Application by Green Hill Solar Farm Ltd. for an Order granting Development Consent for a proposed solar development on land between Northampton and Wellingborough

PINS ref: EN010170

Response to Examining Authority First Questions by Bozeat Parish Council 18th November 2025

Title:
Figure 13A1.2: Transport Links

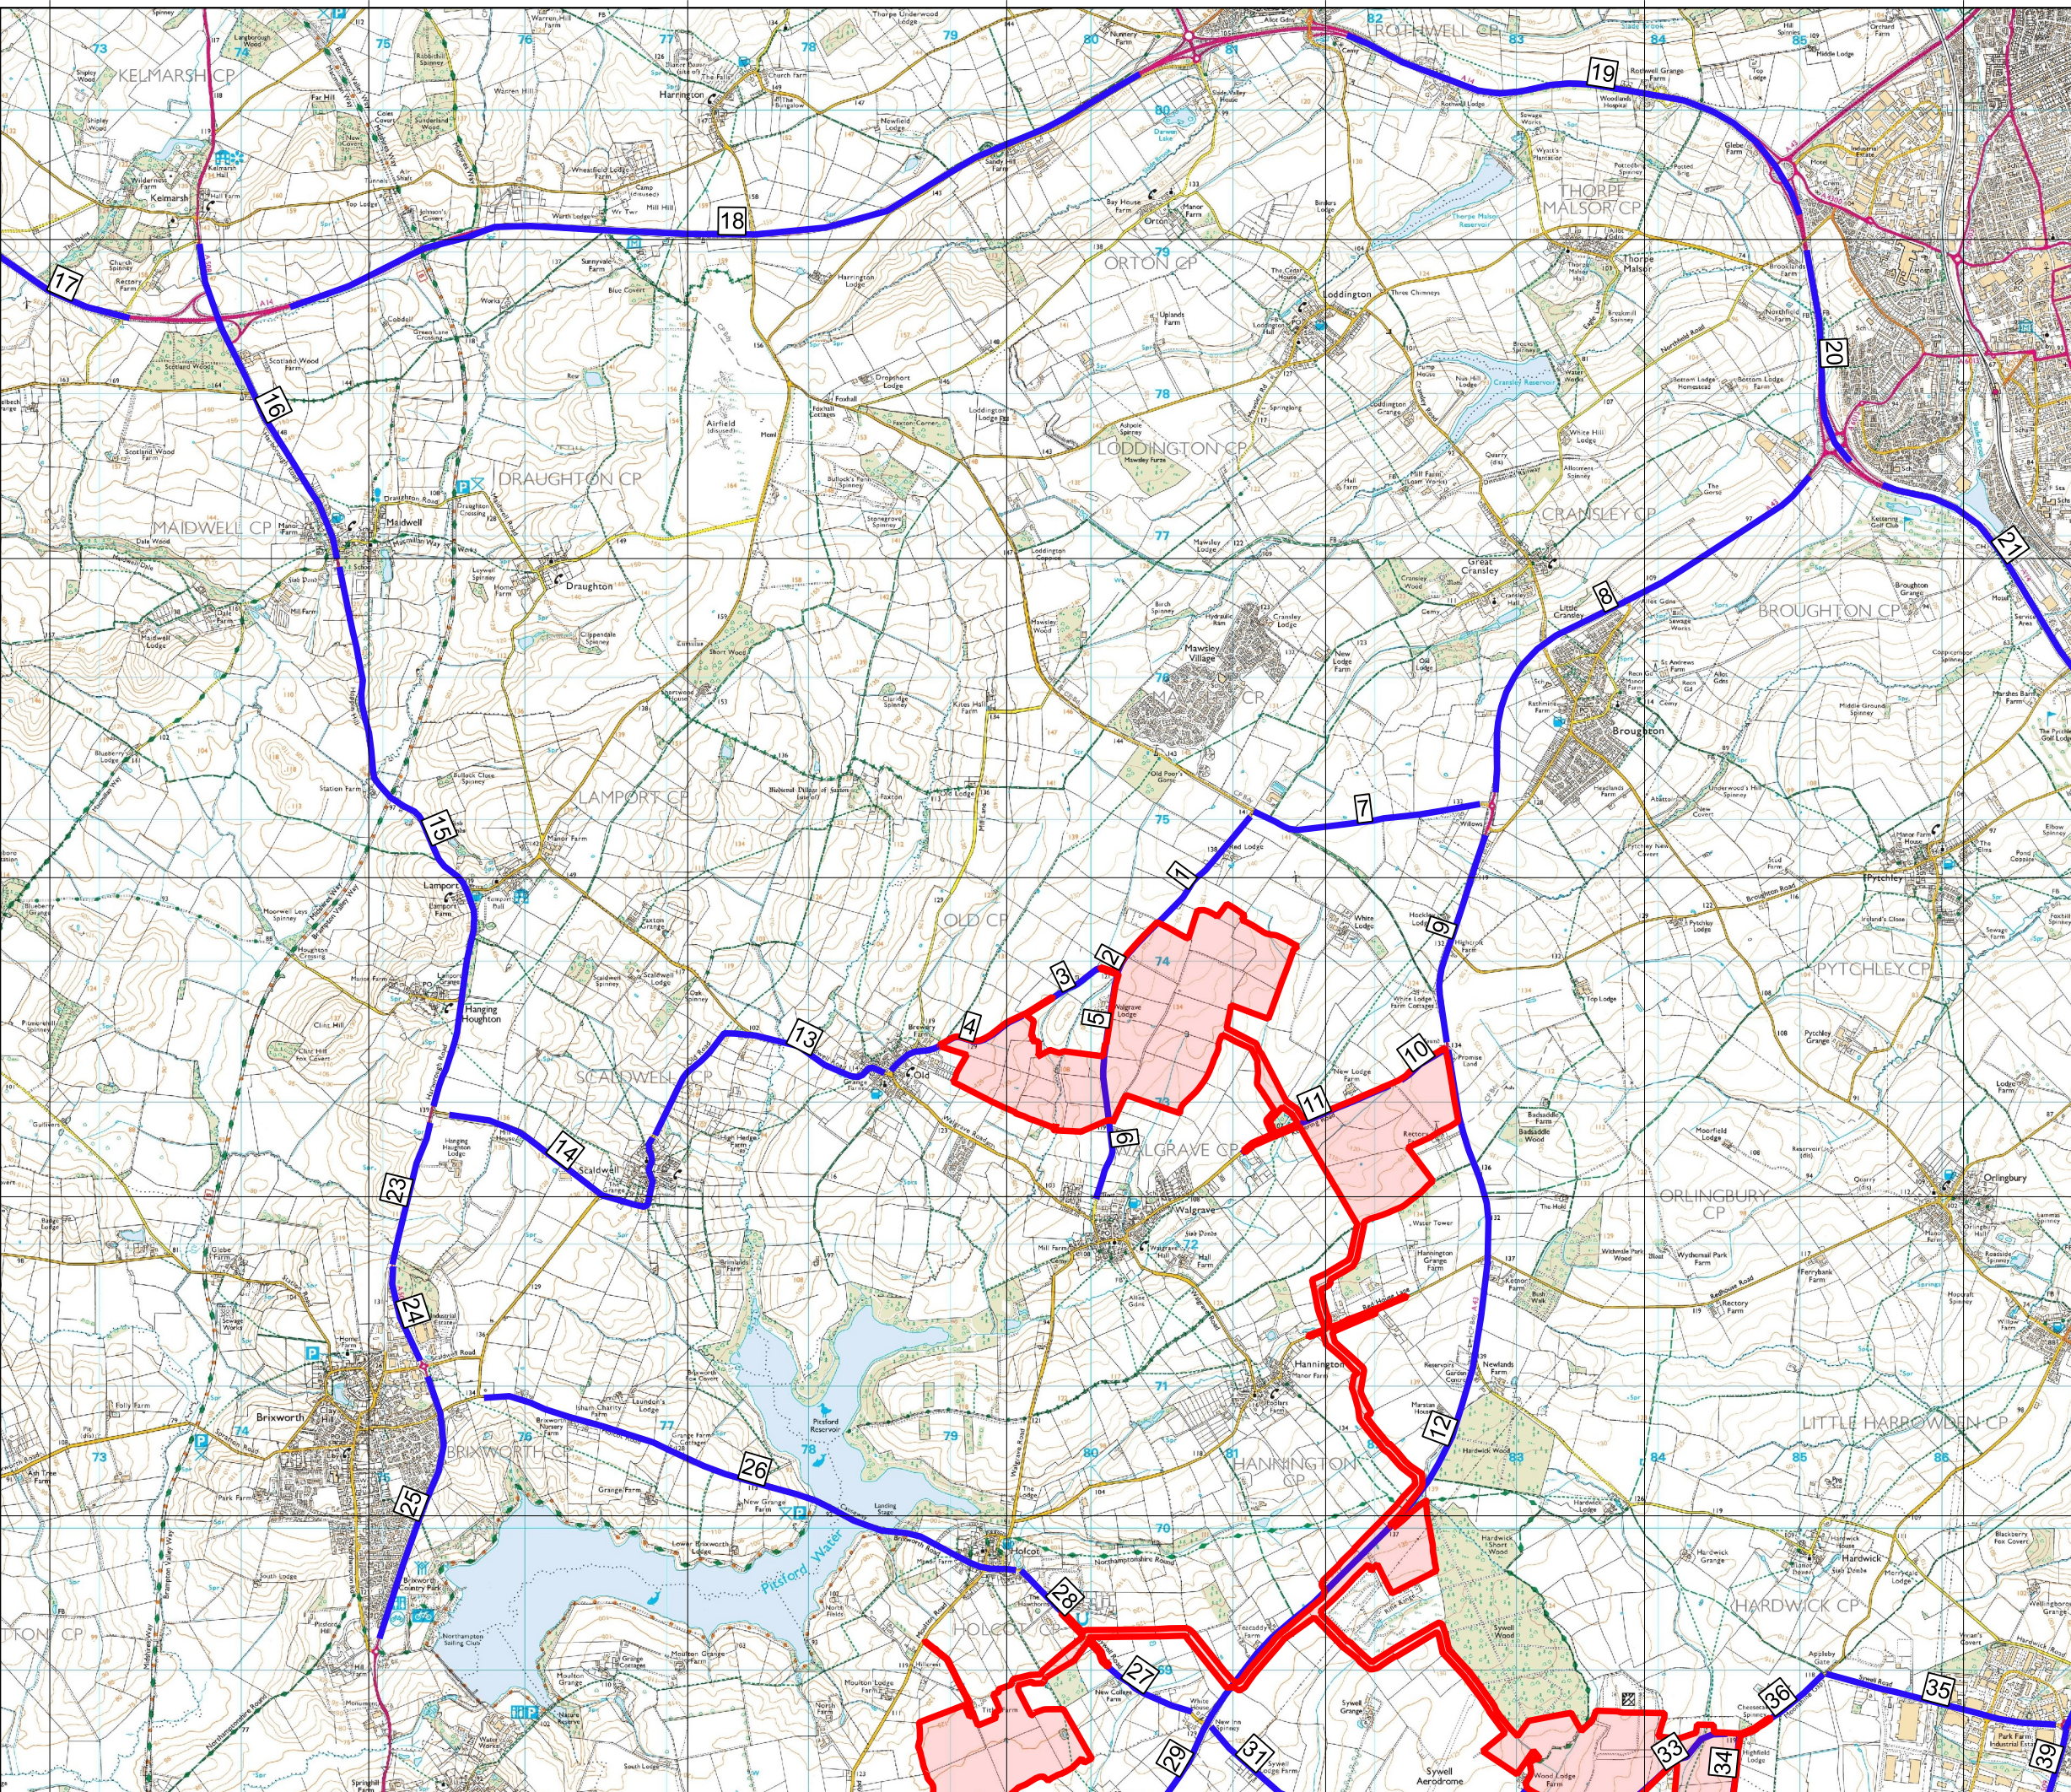
The applicant's response to this does not acknowledge that the cemetery, the parking spaces for several Easton Lane properties, the new-build Ahern Close and a number of individual properties are on the opposite side of Link 81 to the footpaths meaning that pedestrians always have to cross the road. Residents of the Ahern Close development and the individual properties would have to do so to reach all facilities within the village including the village shop, school, churches, community church hall and playing fields.

The applicant's response also does not address the safety of non-motorised users of the road to Easton Maudit.
